**Response to Planning application from Hertfordshire County Council (T and CP GDP Order 2015)**

District ref: 6/2021/3037/FULL  
HCC ref: WH/10031/2021  
HCC received: 2 December 2021  
Area manager: Matthew Armstrong  
Case officer: Bob Meadows

LAND ADJACENT TO COMET WAY HATFIELD AL10 9SL

Installation of a 20m monopole supporting 3 x antennas and ancillary development involving removal of existing 15m monopole

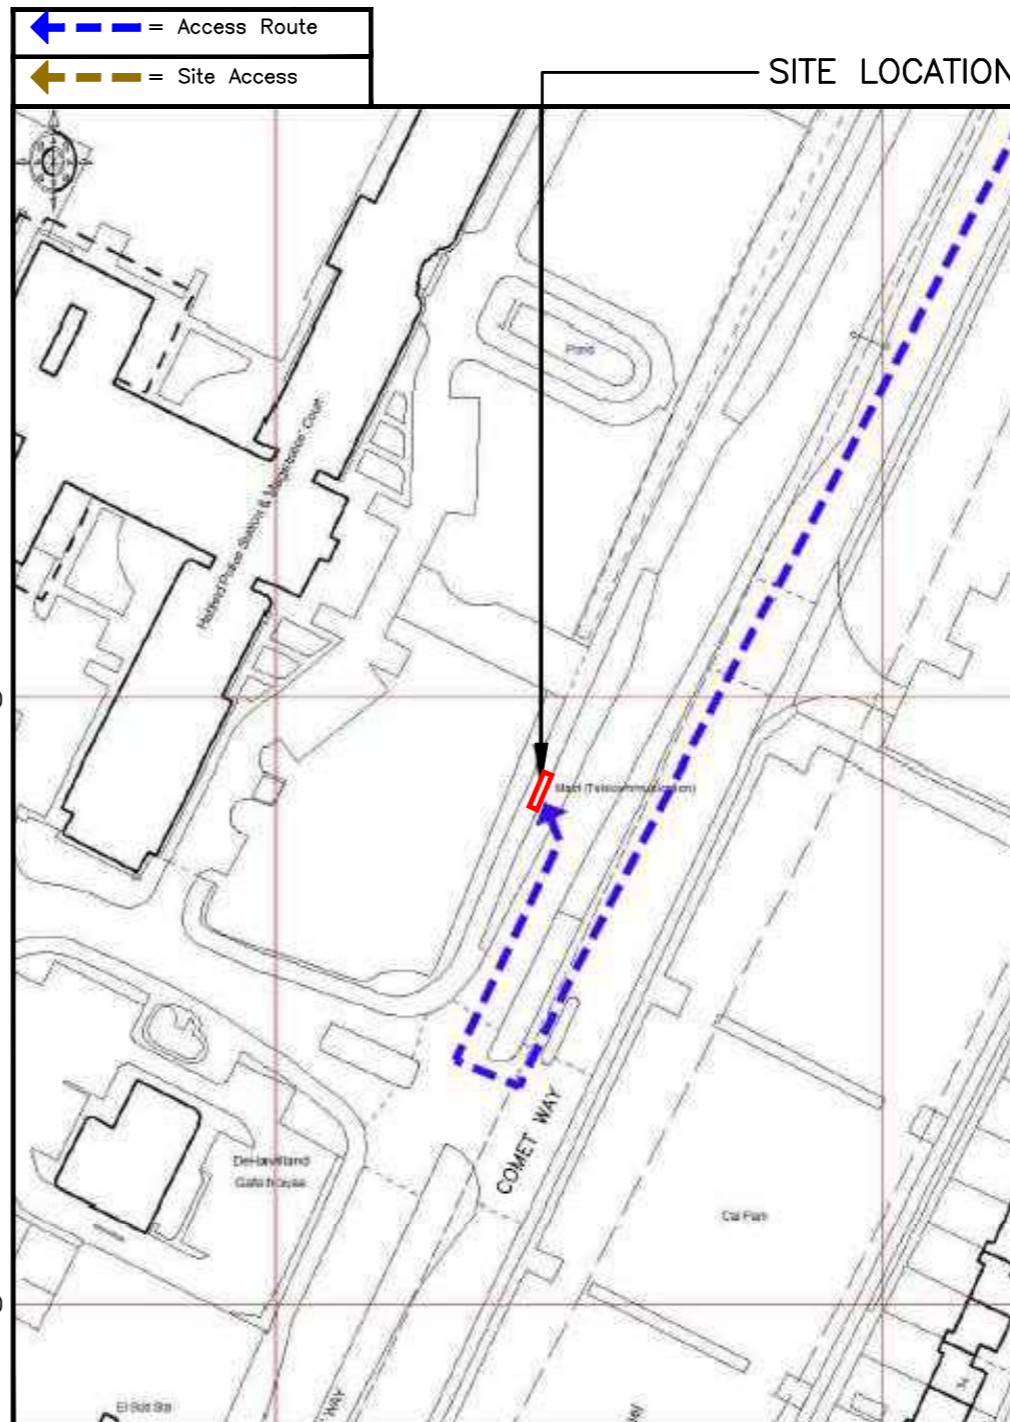
Site plan 201 A shows a new Armco crash barrier within the highway grass verge. The highway authority does not support the use of such a barrier for non highway purposes to protect third party equipment.

Cabinet doors should not open across the cycleway/footpath.

Consideration should be given to relocating some or part of the apparatus to the other side of the cycleway/footpath.
